Department of Primary Industries

OUT16/11626

**Mount Owen Continued Operations Project (SSD 13_5850)
Planning Assessment Commission Request for DPI Water Advice**

DPI Water has reviewed the Planning Assessment Commission's review report and provides the following advice on recommendation 16 of the report.

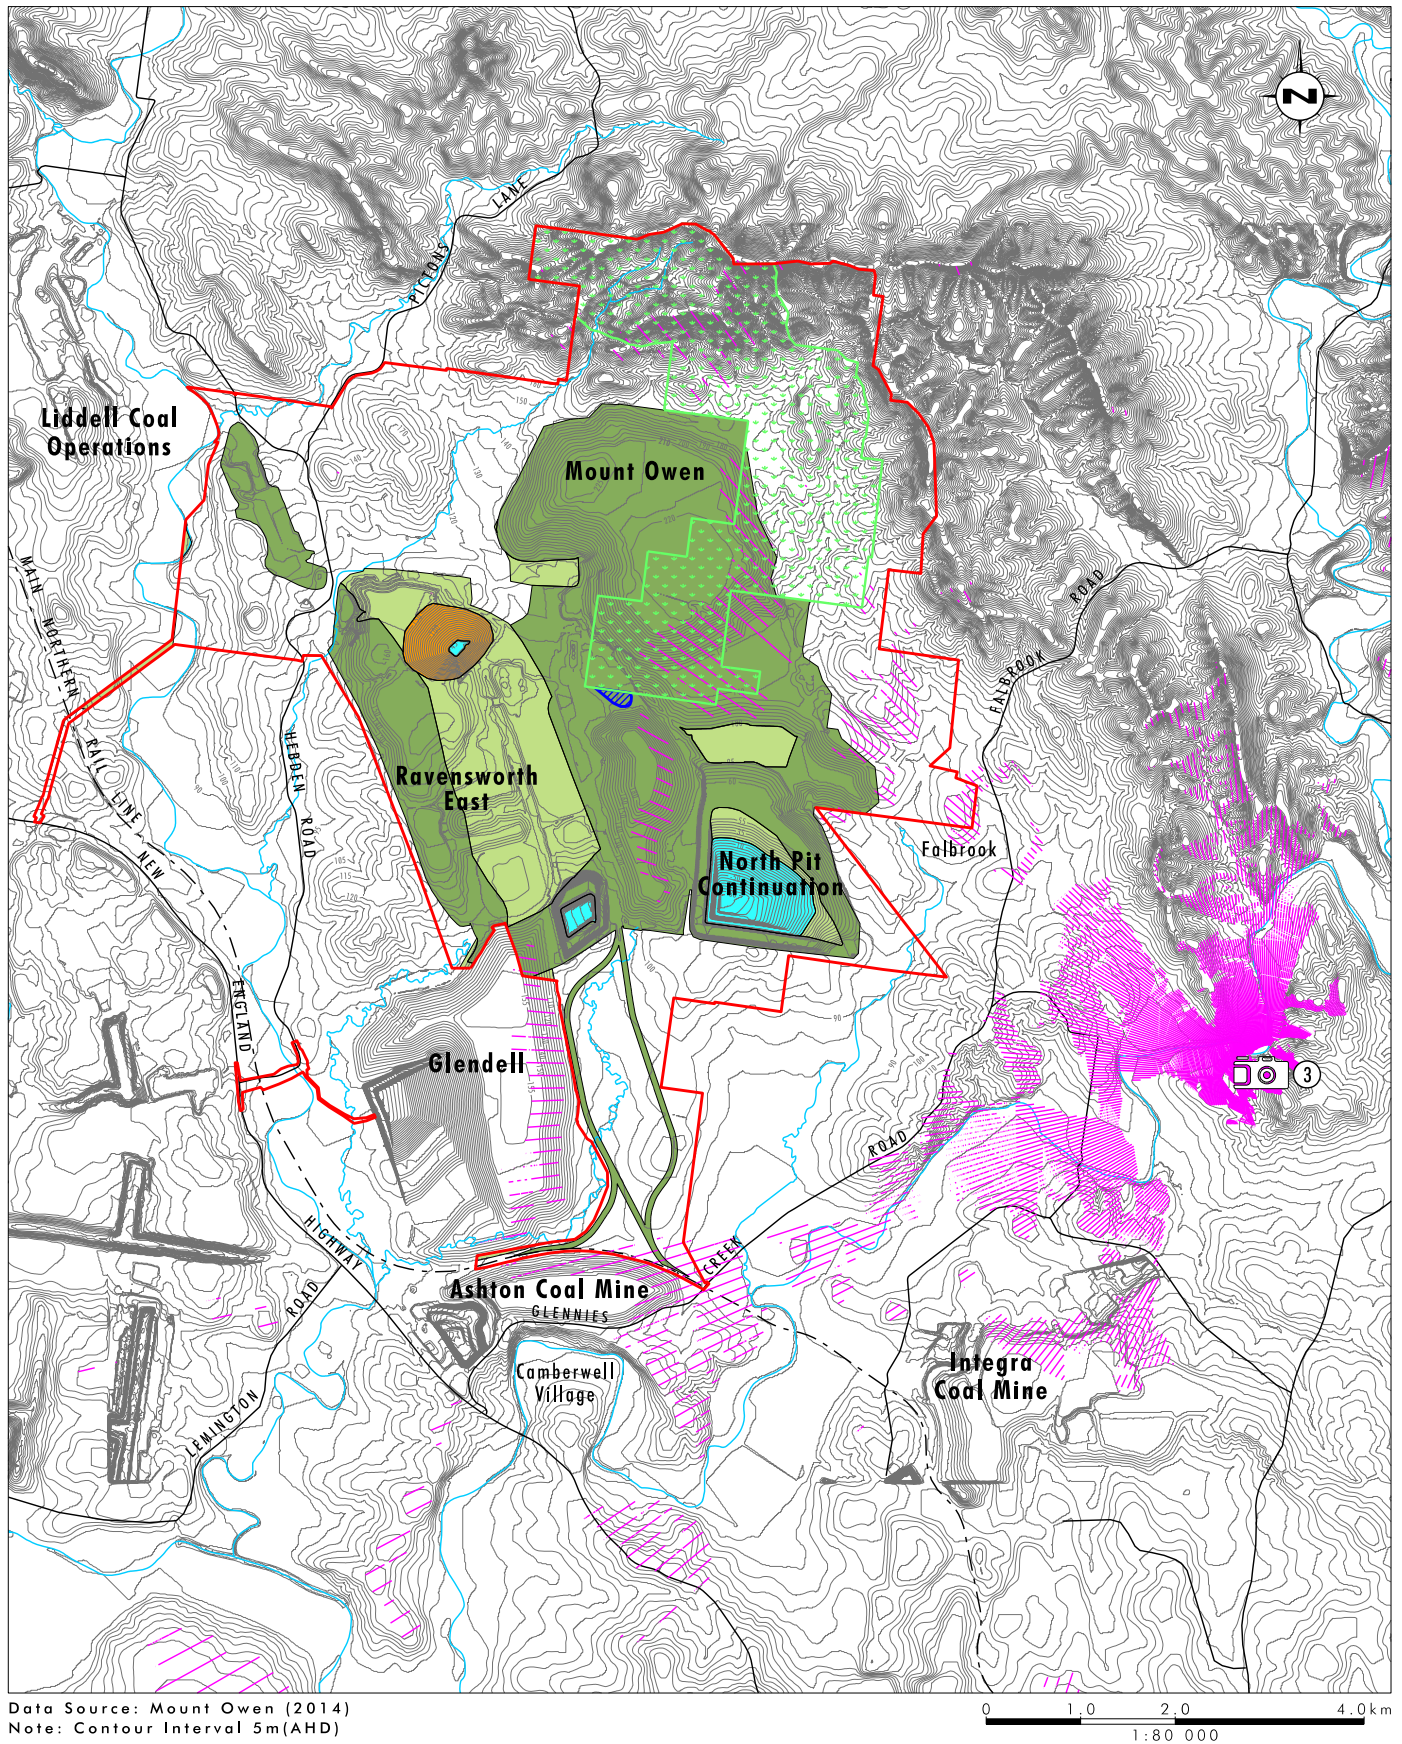
- The water accounting approach for dams in the final landform presented by the proponent only includes water use from the dam, including stock watering and evaporative water losses. DPI Water requires the total volume of dams to be accounted for, rather than just the stock watering and evaporative losses. DPI Water notes that the surface area of dams to remain is calculated by the proponent as approximately 47.8 hectares in total. It is likely that the total volume of the dams currently proposed to remain in the Jerry's Water Source will still exceed the 200ML of entitlement held and the proponent's harvestable right combined.

- In previous correspondence DPI Water requested that where the water captured by dams is intended to be accounted through harvestable rights, consideration should be given to the final ownership of the land to ensure the dams will be within the maximum harvestable right, or otherwise licensed or decommissioned. The proponent has not provided information to address

this. The proponent calculates their harvestable right based on their current total landholding of 4913 hectares and has not provided information on the likely ownership of land following rehabilitation of the mine, including any breaking up of land ownership as part of the proposed future land use and how this may impact on the legality of dams remaining in the landscape.

Further design of the final landform water management system should be included in Water Management Plans for consideration of DPI Water. This should include specific consideration of individual dams, their specific purpose, their capacity, and under what mechanism they are proposed to be accounted for.
